Application 3/2011/695 proposed new dwelling at land adjacent to Mount Pleasant & 52 Padiham Rd Sabden

Sabden parish council OBJECT to the proposed dwelling for the following reasons :-

Elevation to Padiham Road

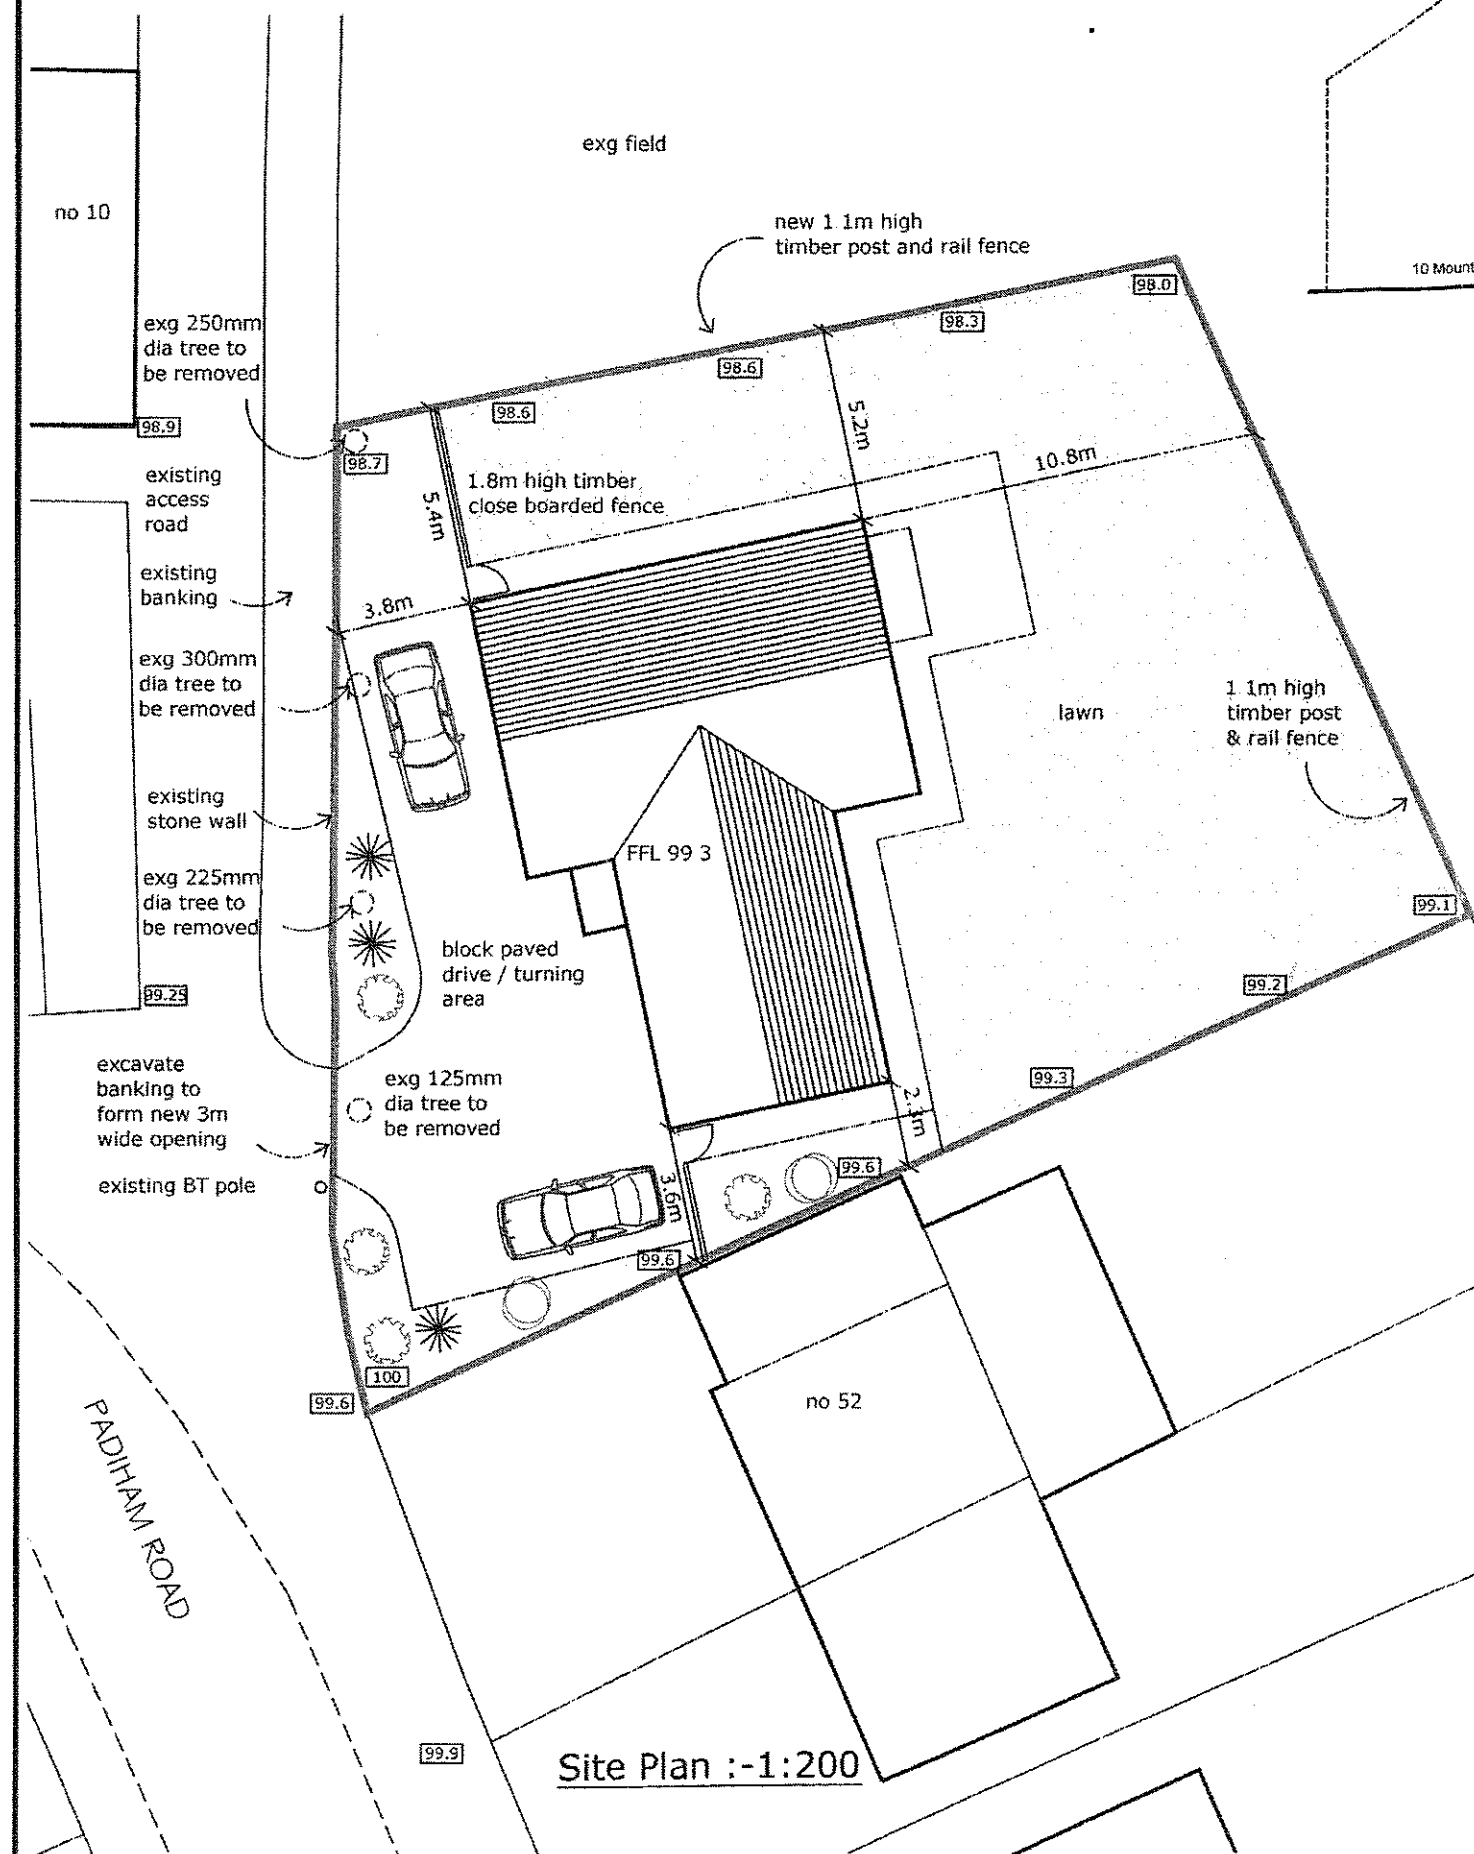
- The proposed dwelling is higher than dwellings which are adjacent on Mount Pleasant & Padiham Rd & this council believe as such it is out of scale & will be detrimental to the area.
- The proposed access is to the left of an existing BT Pole where there is more limited space & requires removal of existing Trees, there appears to be more space to the right of the BT pole
- This council question if there is root damage to existing trees & suggest a full tree survey be conducted by a professional.
- The proposed dwelling is on a site which is agricultural & until fairly recently has been farmed by the neighbouring farm
